Rezoning Transportation Analysis

Petition Number: #2022-125

Revision Log:

Transportation Summary

RZ-2

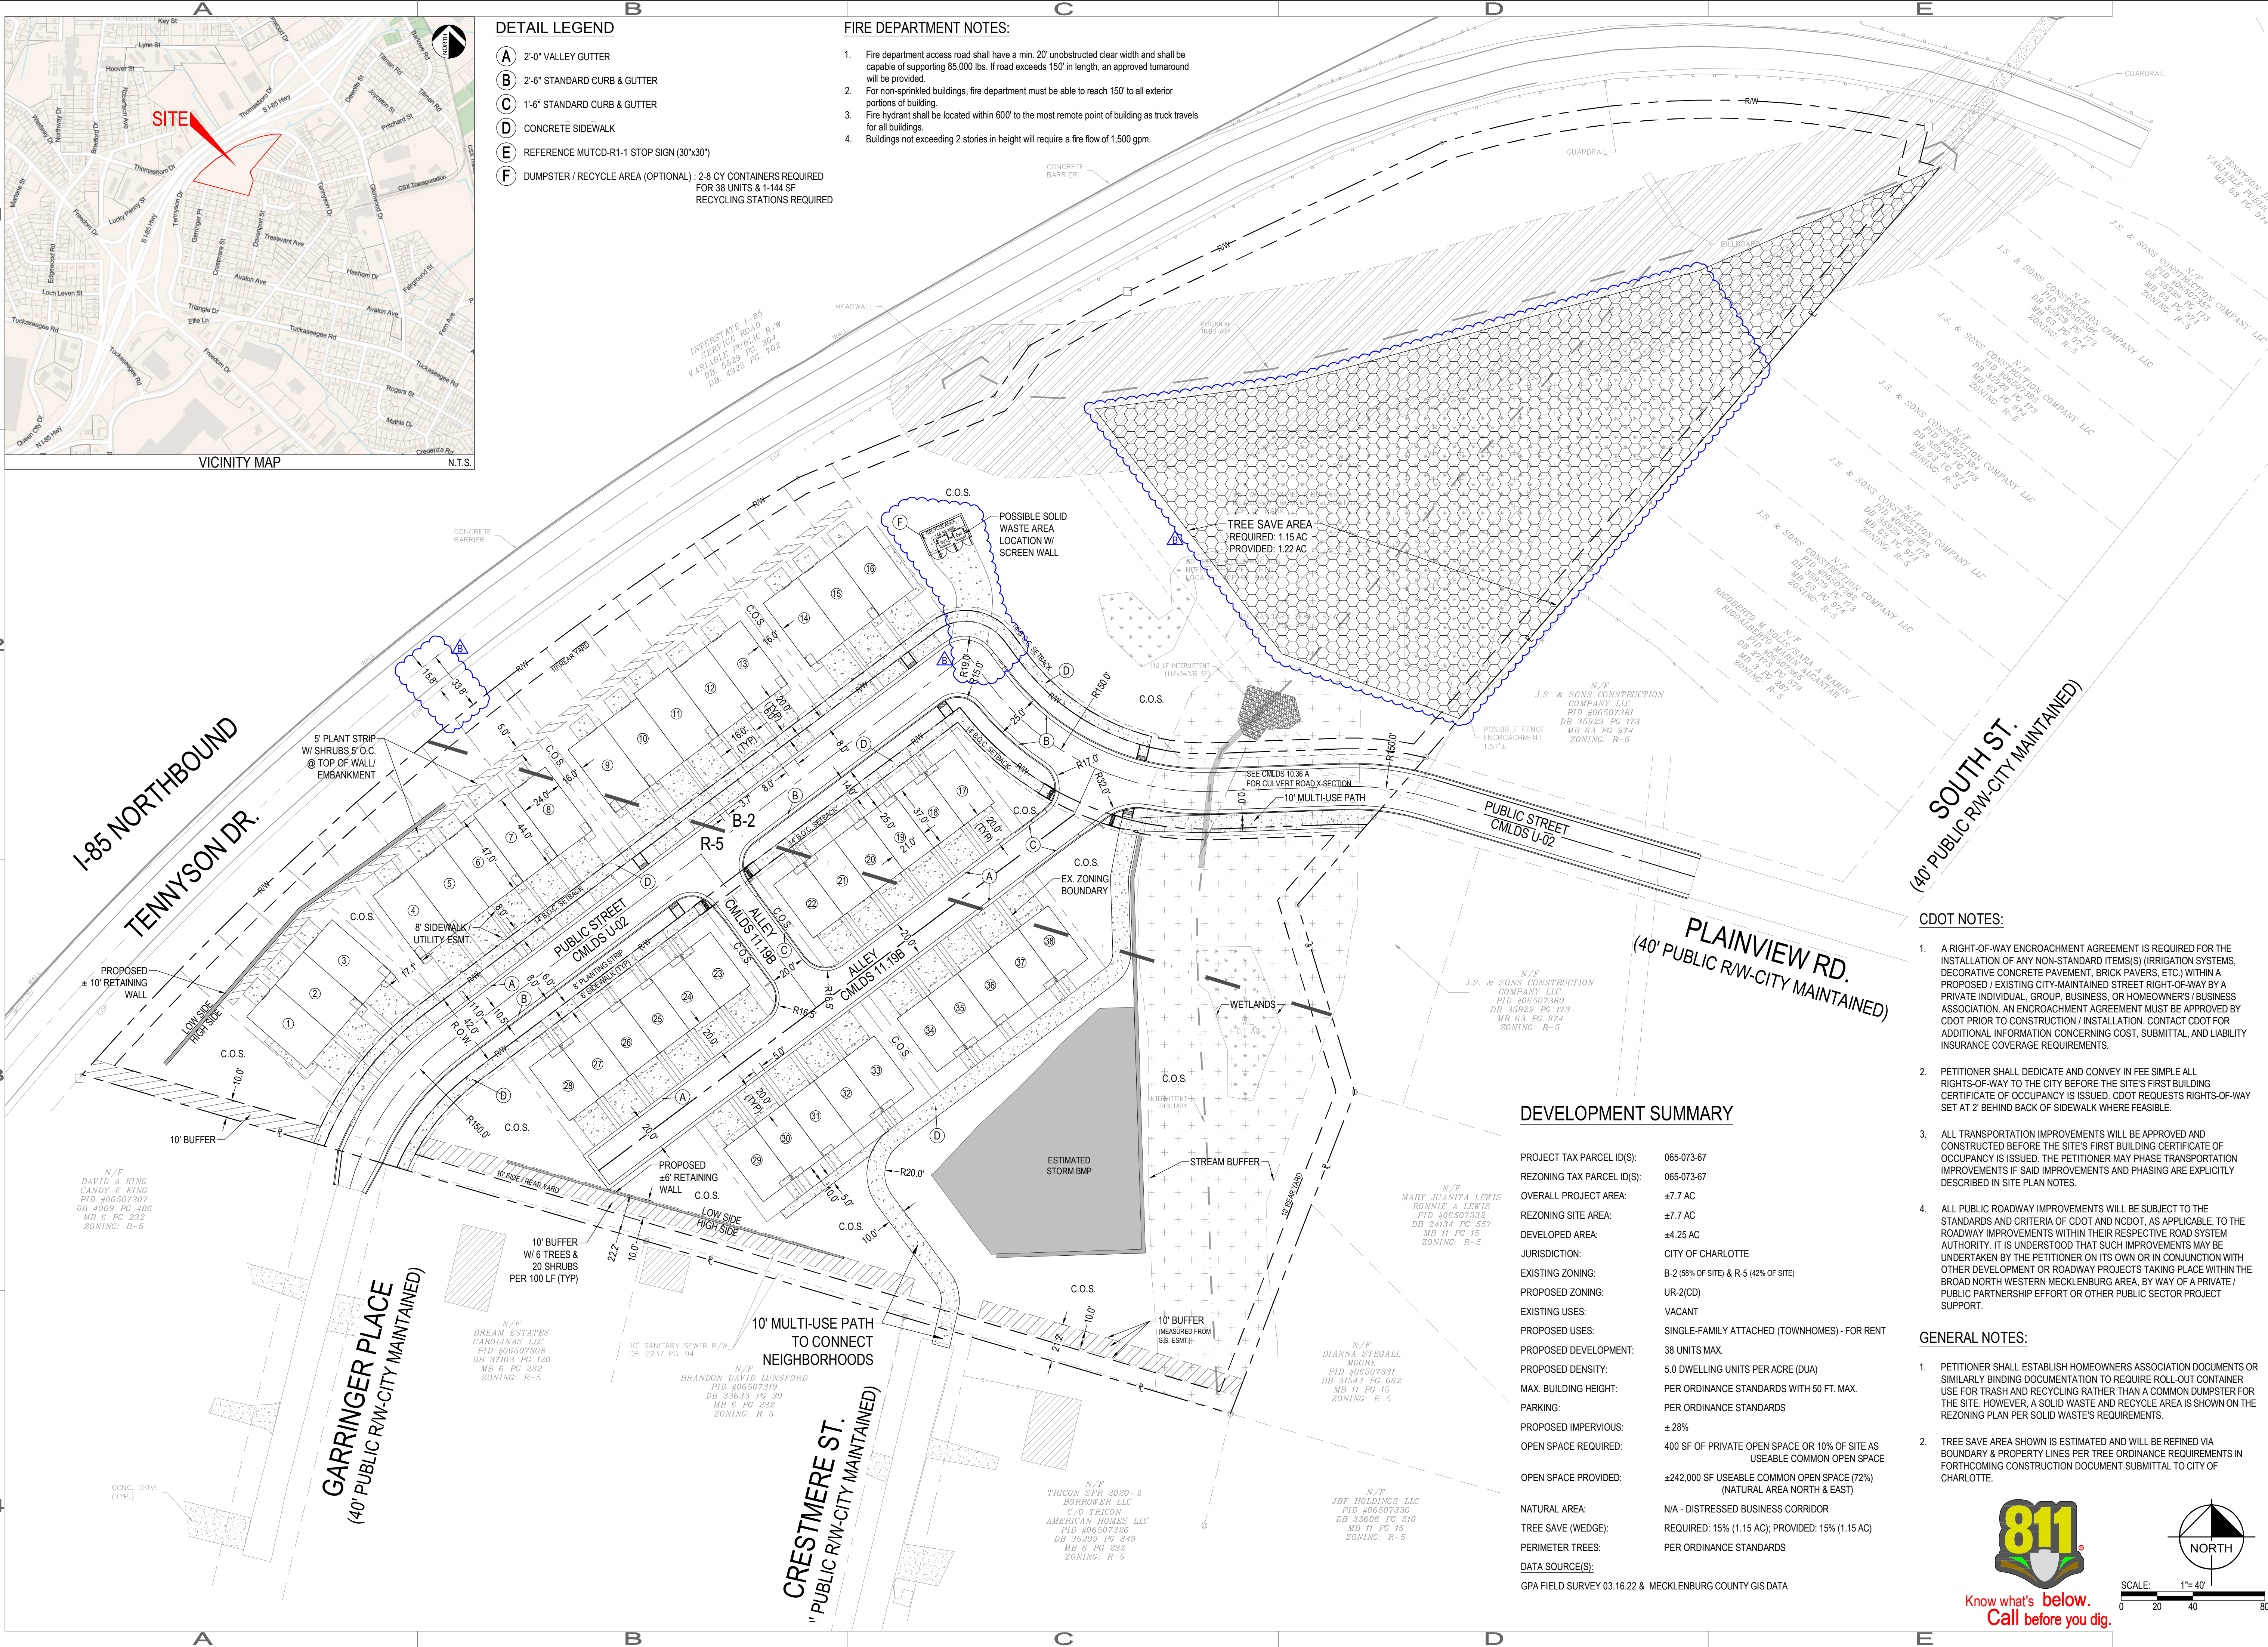
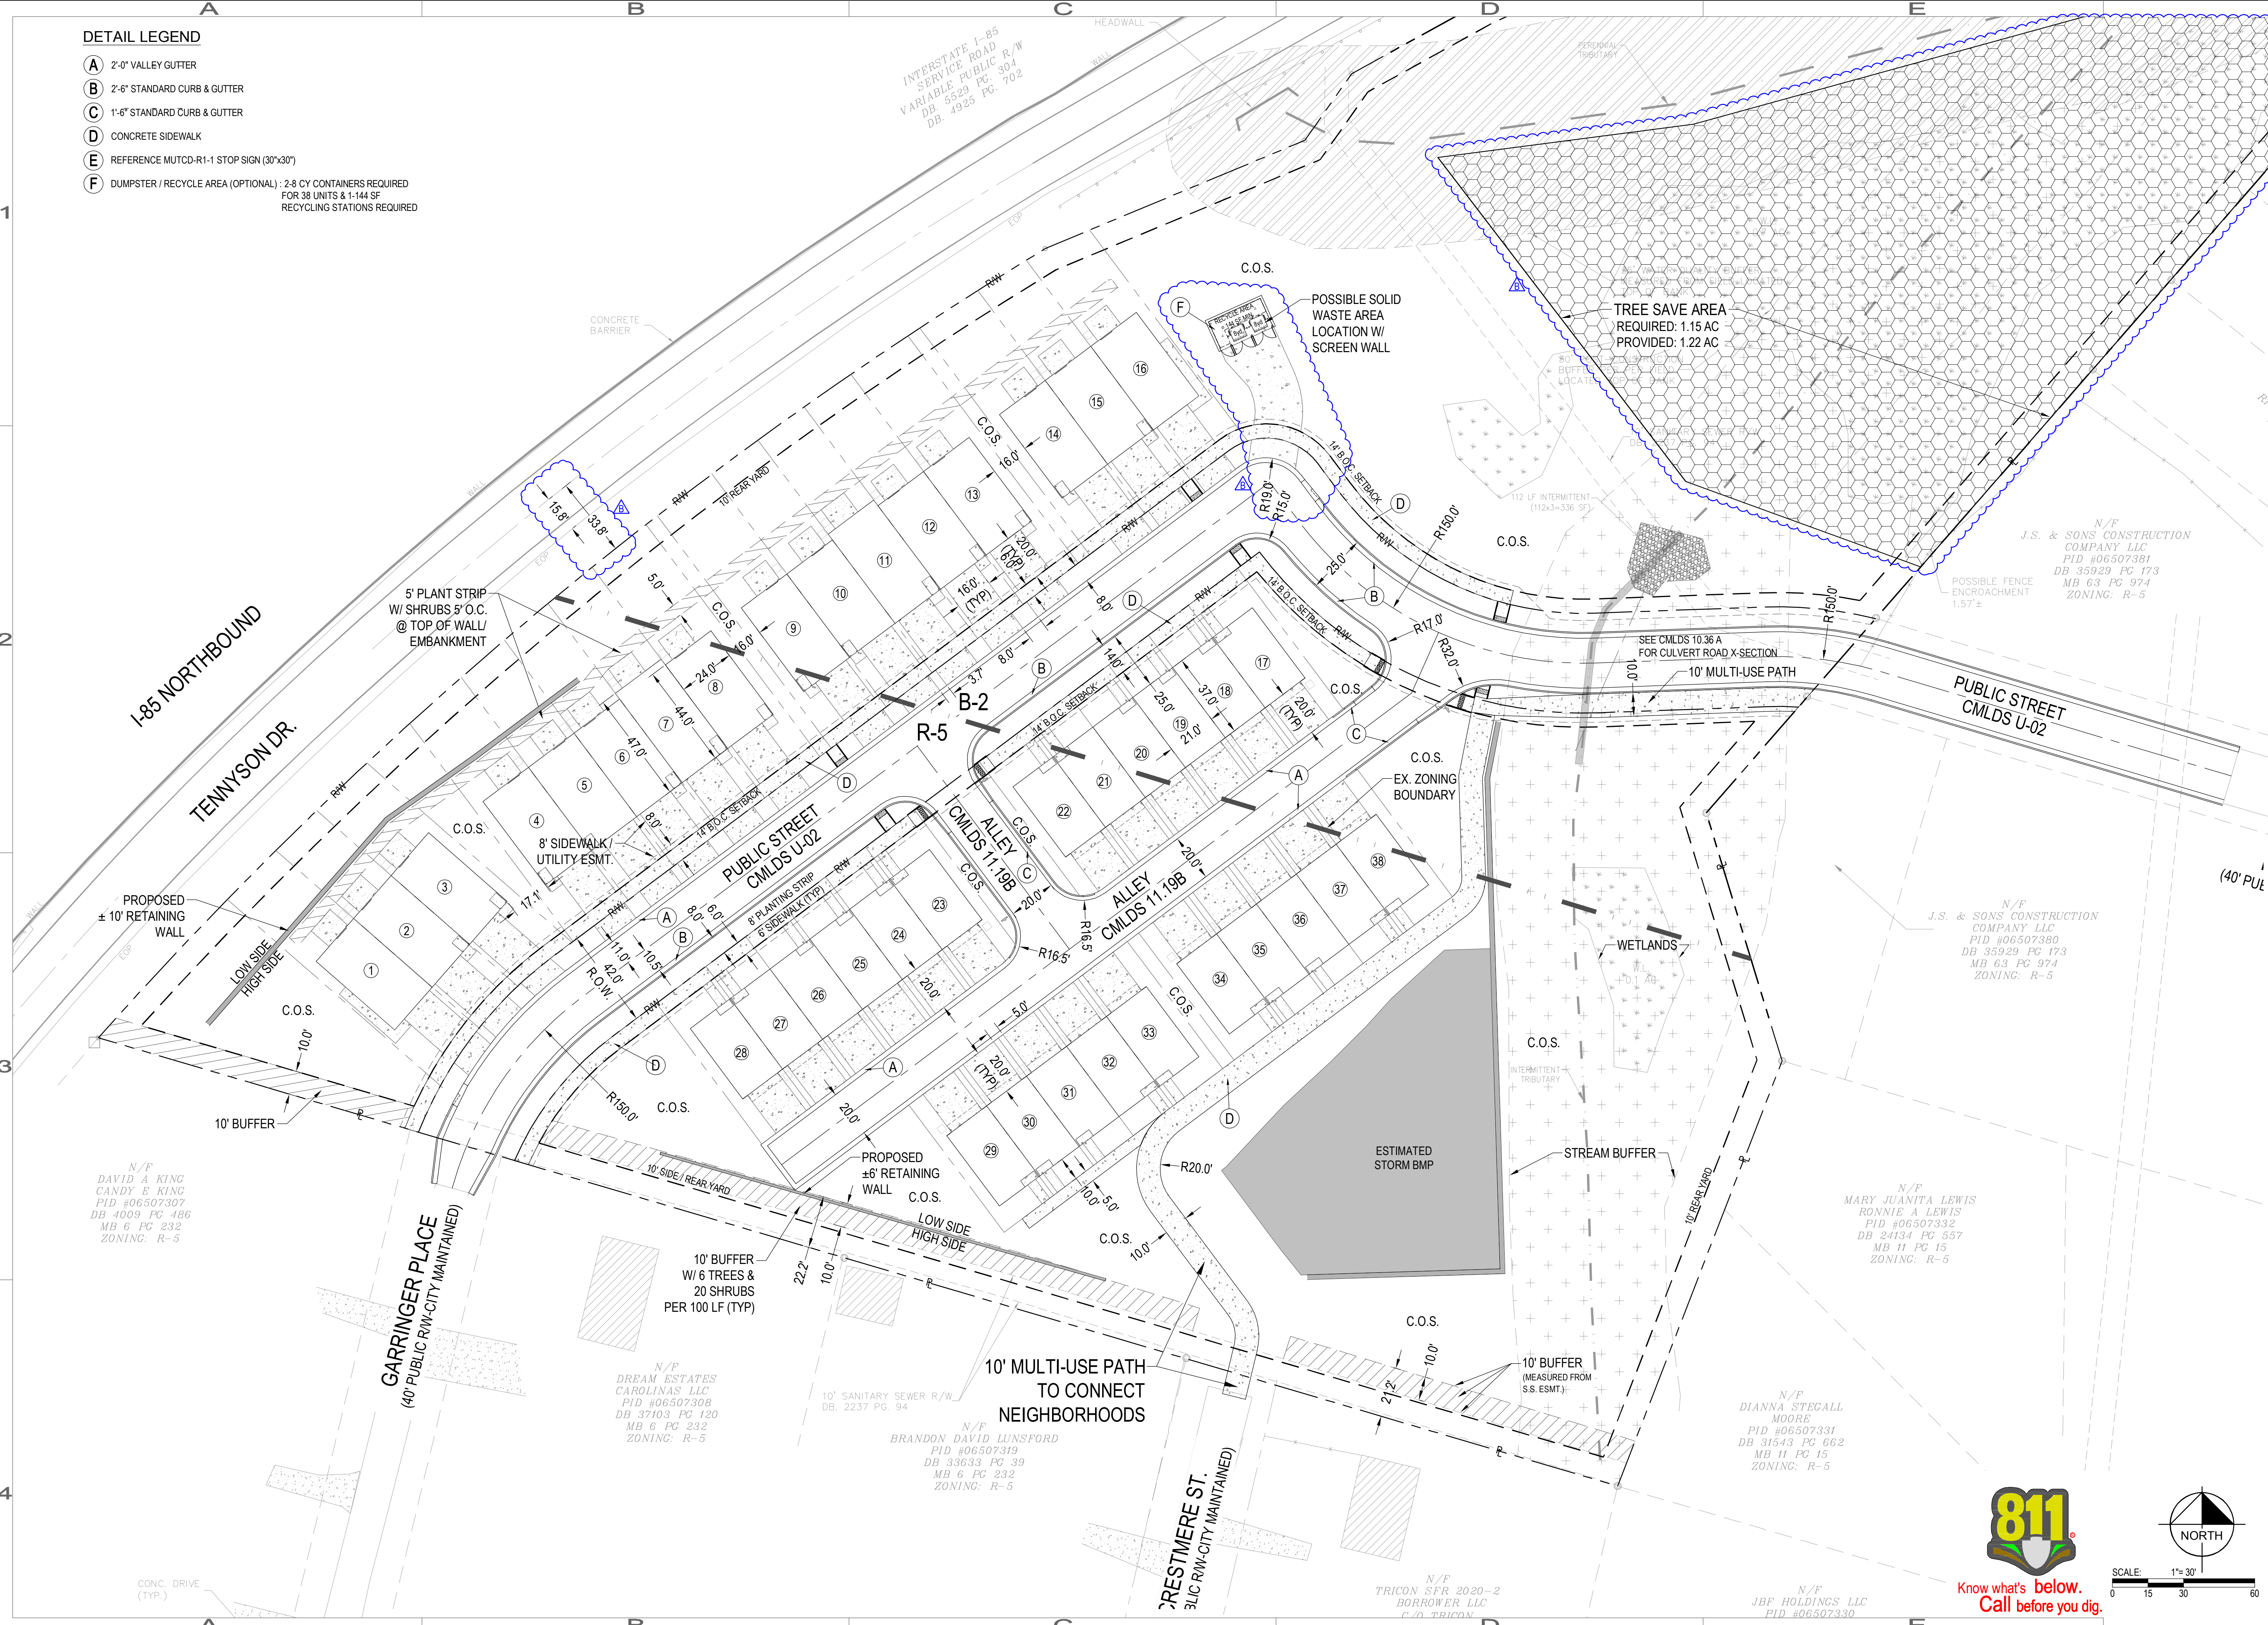
Clarifying Comment 01-27-23: CDOT will not accept current design. Revise roadway to remove 90 degree turn and satisfy CDOT standards for public roadway geometry. Remove crosswalk, stop bars, and stop signs.

11. **NEW CDOT COMMENT (02-22-23):** CDOT will not accept current design. Revise roadway to remove 90 degree turn and satisfy CDOT standards for public roadway geometry.
